Submission No.	112
Organisation Name or Name of Submitter	Hedigans Limited (Michael and Peter Hedigan) - represented by Hughes Planning

Re: Planning Observation ABP Ref. No. NA29N.314724 - Railway (Metrolink - Estuary to Charlemont via Dublin Airport) Order

GLASNEVIN STATION - CROSS SECTION
1 : 100

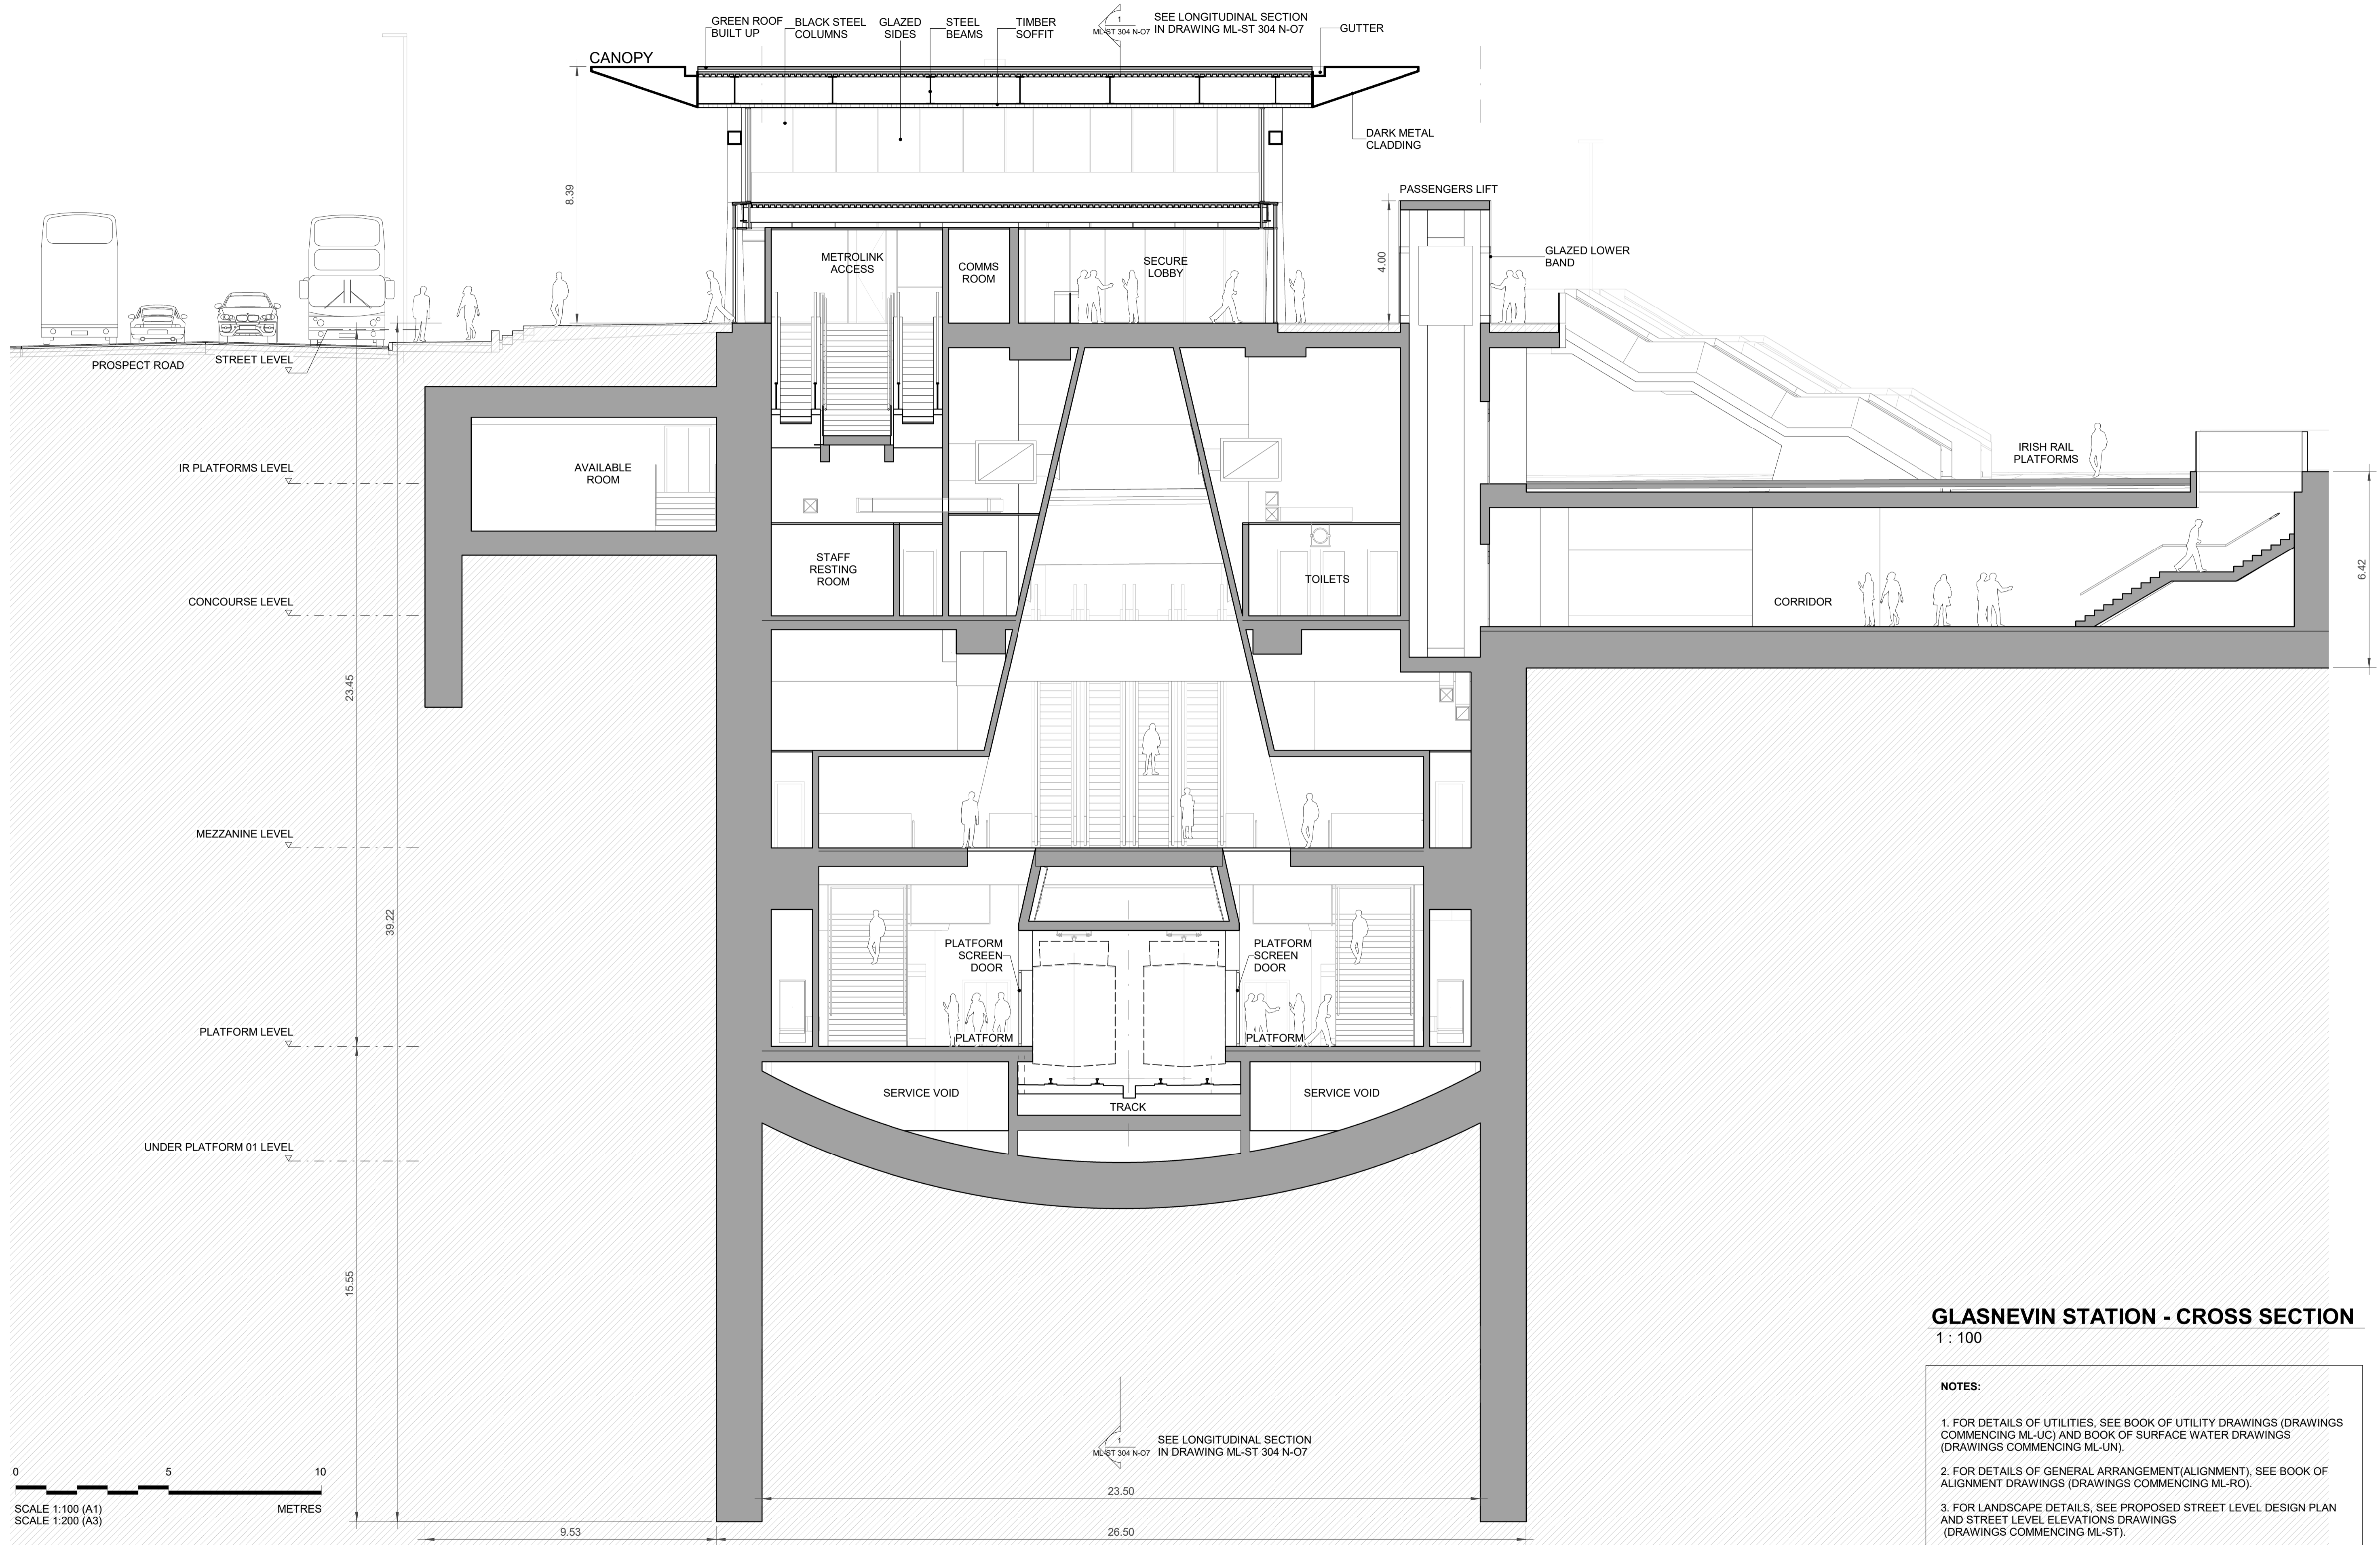
22	Appendix A, Memo prepared by Dermot Flanagan, Barrister-at-Law, point 4 (page 3)	27	It is submitted that there has been a failure in this design to consider the integration of the new station with the rear area comprising the existing carpark of the Hedigan's Brian Bora Public House such that its pre-existing development potential is maximised in conjunction with the construction of the new station at Glasnevin.	The location of the impacted property is at the location of the proposed Metrolink Station which integrates with the DART + and forms a major interchange for public transport. Demolition of concerned property and residual car park area is required for the Metrolink works and for the integration with DART + to serve as an Interchange Station including for access/ egress. The existing car park at the rear is required for overall Metrolink works including drop-off for accessible vehicles, access to maintenance vehicle, cyclists parking, utilities and drainage works.
